TfNSW Reference: SYD21/00981/04

Departments Reference: SSD- 25725029

**RESPONSE TO SUBMISSION - ARDEX WAREHOUSE & MANUFACTURING FACILITY - 657-769
MAMRE ROAD - KEMPS CREEK**

Existing Public Transport Routes

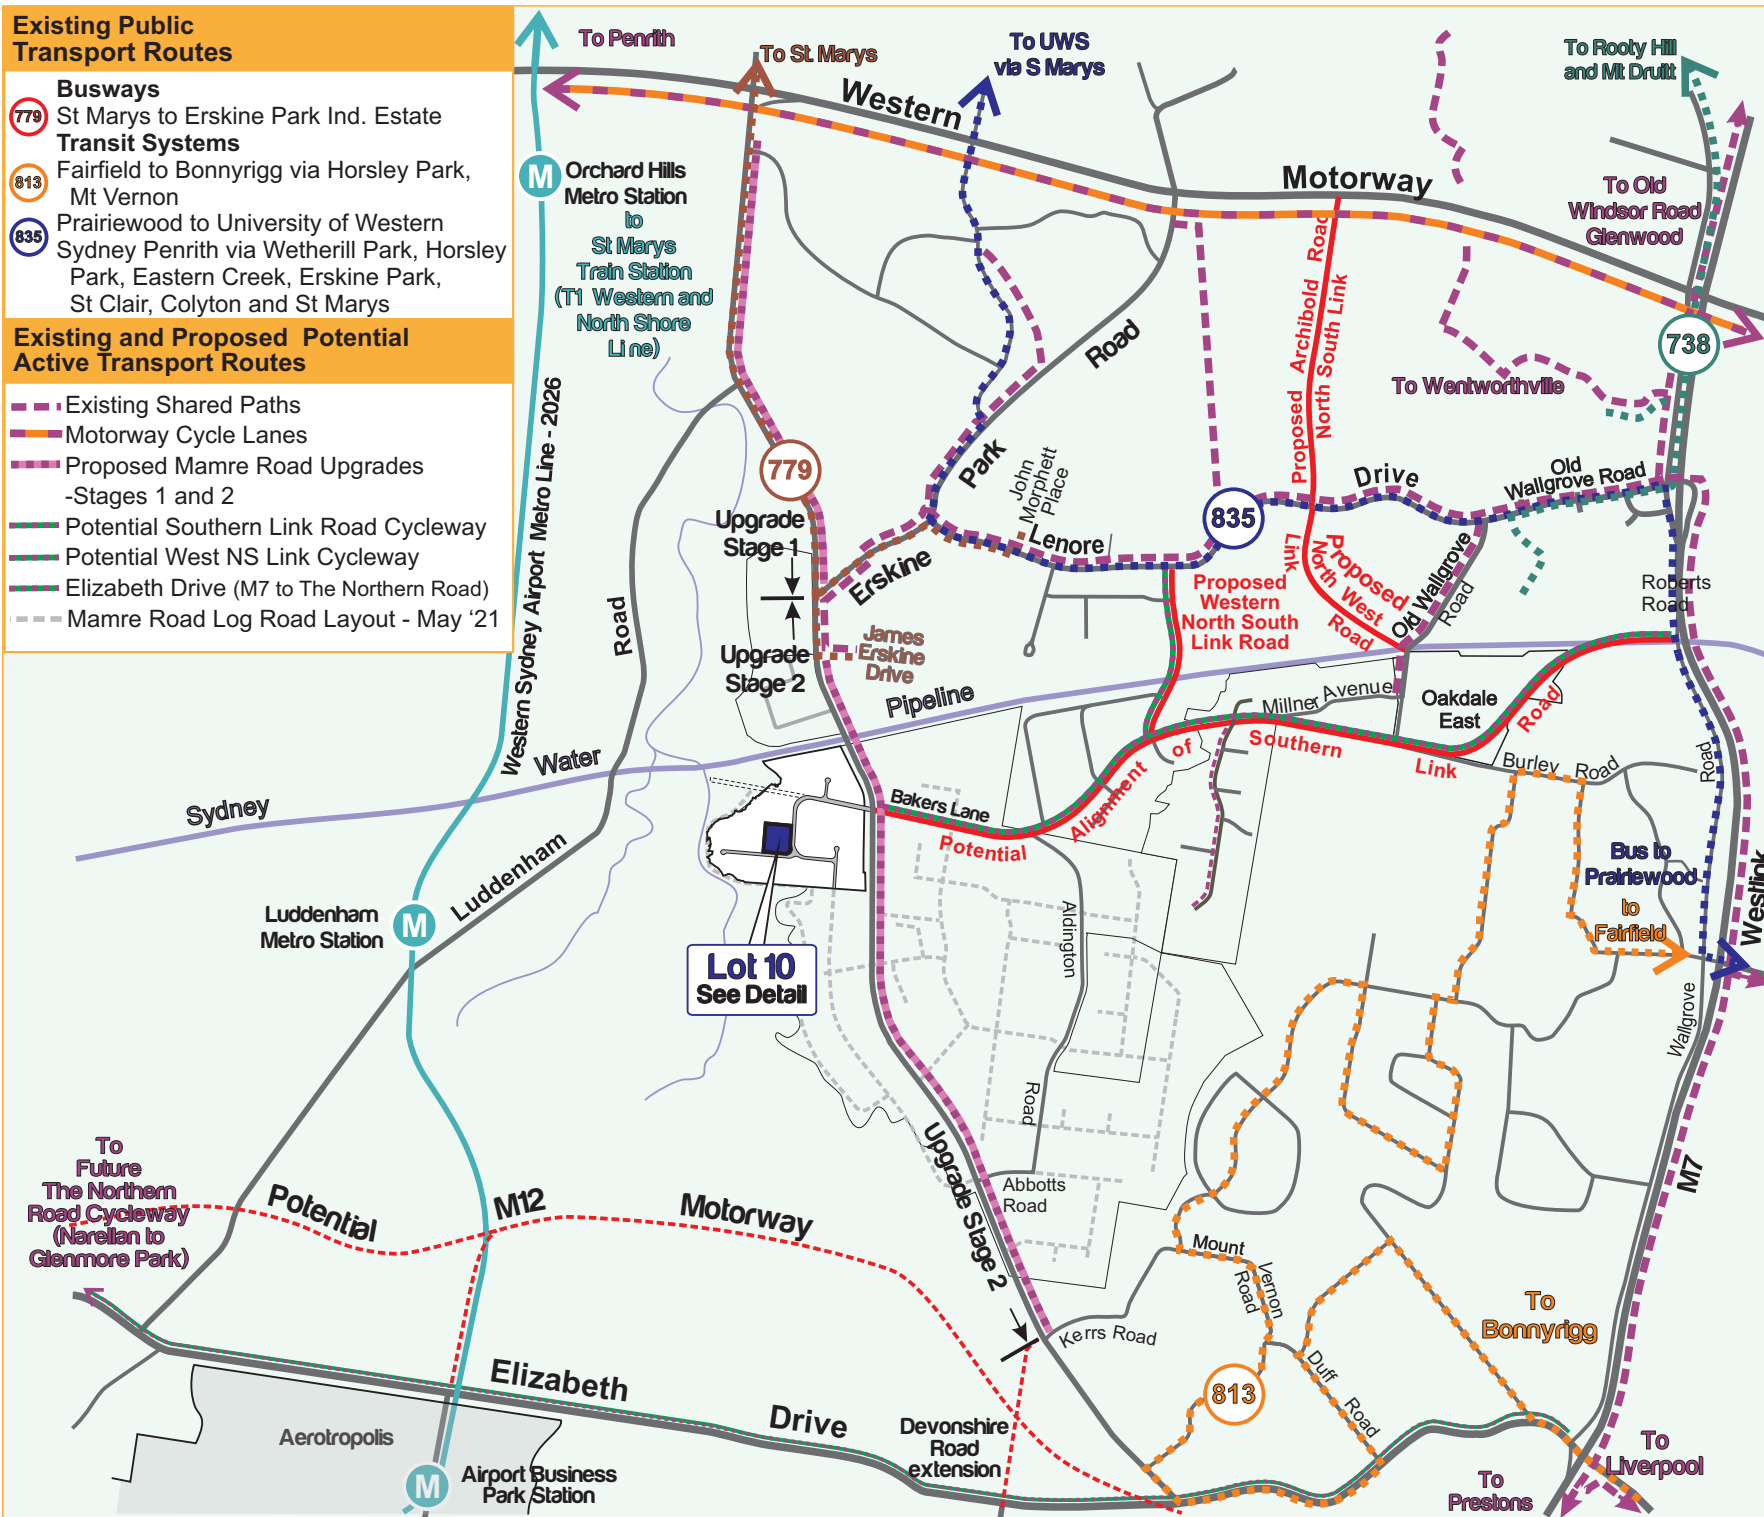
- **Travel Access Guide (TAG):** TfNSW appreciates that a TAG has been provided in Appendix A of the GTP. TfNSW asks that the TAG caters to everyone who is using the proposed development site: employees, customers and visitors. The TAG will need to be updated on a yearly basis. The backbone of the TAG is to reduce single occupancy car use, and encourage sustainable transport journeys to and from the site using public and active transport. Therefore we would recommend that the TAG:

- Provide additional information about service routes and timetables for buses and trains on the Trip Planner at transportnsw.info/.
 - A more detailed diagram / map showing the location and number bicycle parking spaces and EoT (noting there is a small inset in bottom right of the TAG).

- Provides detail of any shuttle bus services to be provided
 - For further helpful information – please check this link [How to Create a Travel Access Guide doc here.](#)
